Your Ref: OWPC5072
Our Ref: R/15/15/PL 21-01-2015
Please ask for:
Mr D Easton

Proposed installation of 2 no. velux style windows to east and west roof elevations
1 Merton Avenue Rustington

(WEST) SIDE ELEVATION - PROPOSED

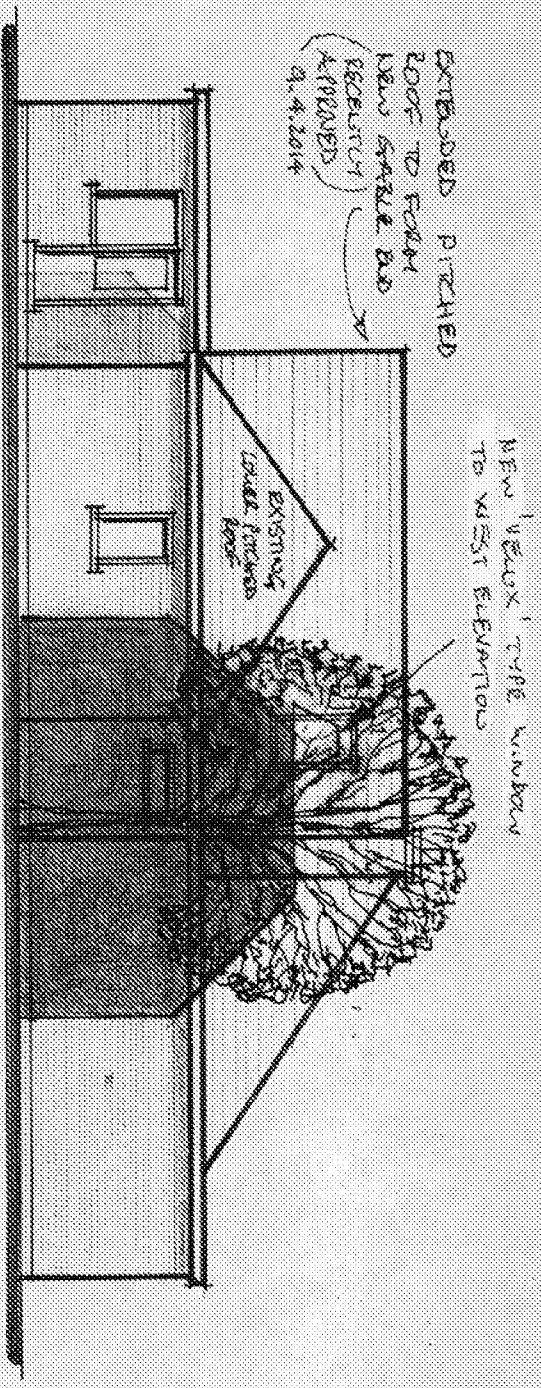
We strongly object to the proposed installation of a Velux window to the west roof elevation of No.1 Merton Ave.

The proposed window will overlook our main garden and patio area, bedroom and kitchen windows as well as our sun room which we use all year round thus preventing us having privacy in these areas.

The mature tree shown on the sketch does not have dense foliage and will not prevent a clear view from the window into our main living and sleeping areas.

A velux window in the proposed location is out of keeping with the rest of the neighbouring bungalows.
